# CITY OF PORTLAND, MAINE

May 1, 2018

**Project Name:** Building Conversion  
**Address:** 415 Cumberland Ave.  
**Applicant:** Sam Reiche  
**Planner:** Christian Roadman

**Project ID:** 2018-011  
**CBL:** 36-G-33

Sheet Title:
SITE PLAN

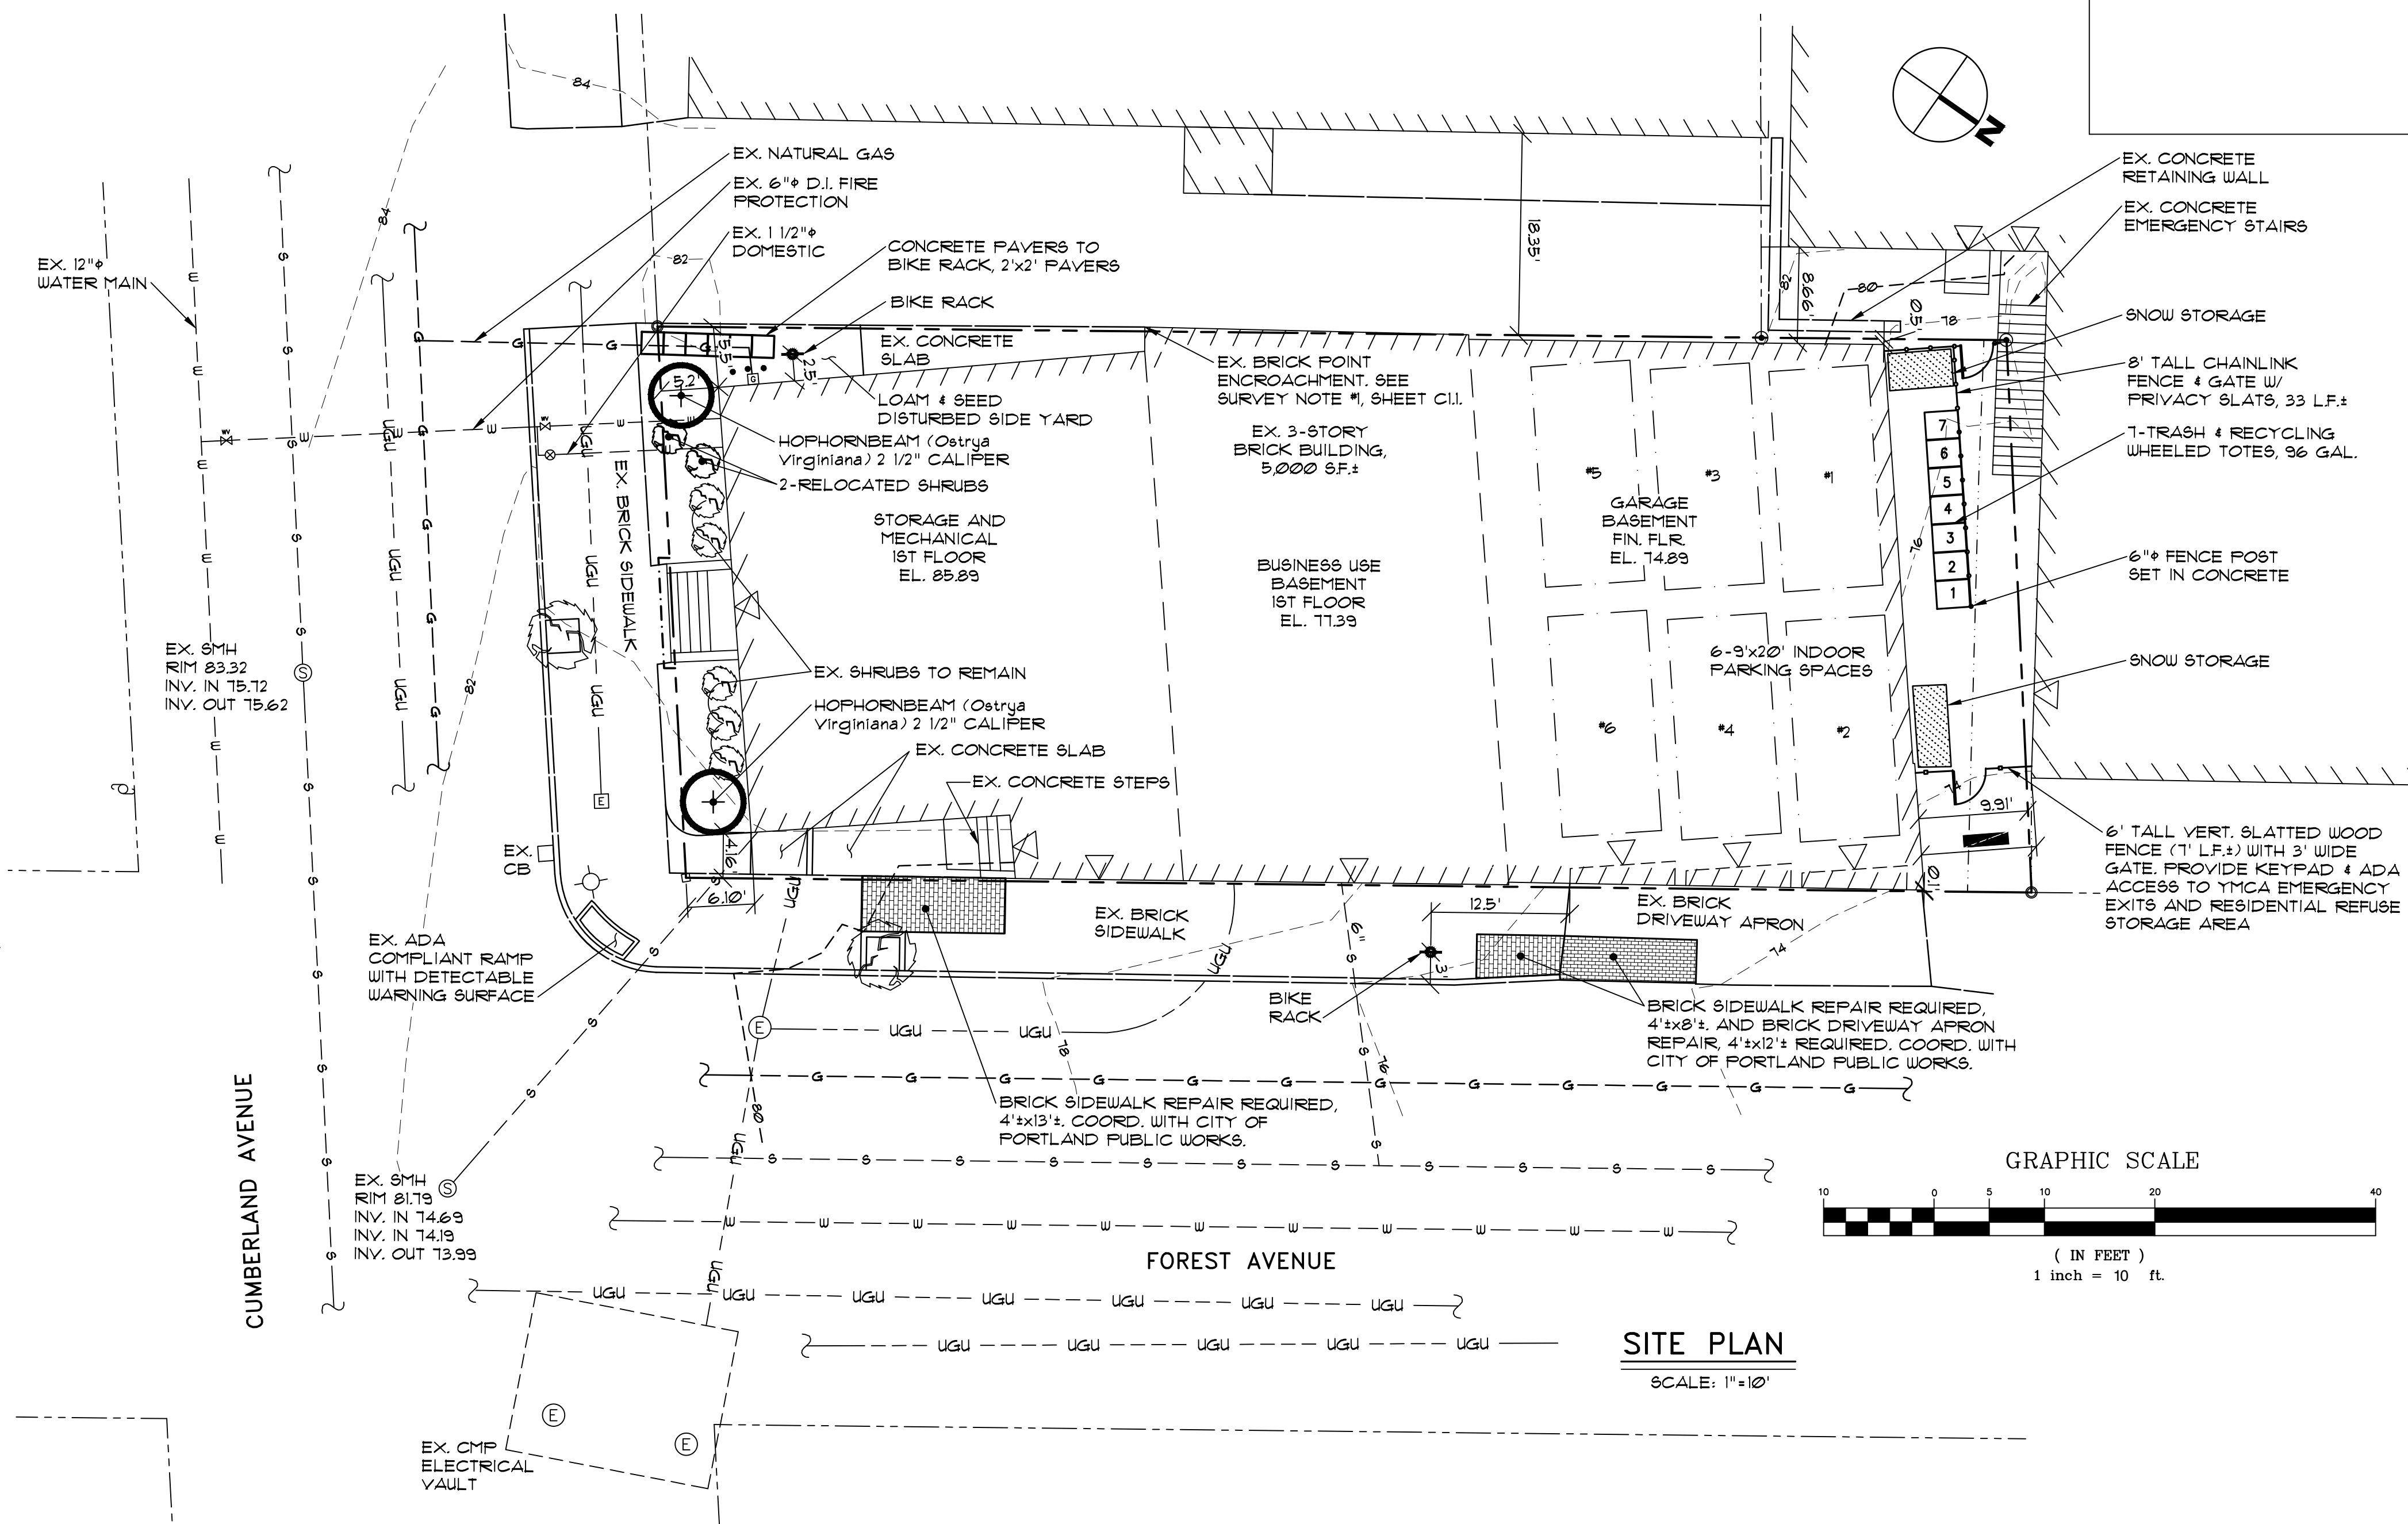
5. The applicant shall pay into the City's street tree fund, at a cost of \$400 per tree, to account for each of the four trees not provided per the City's Technical Standards.
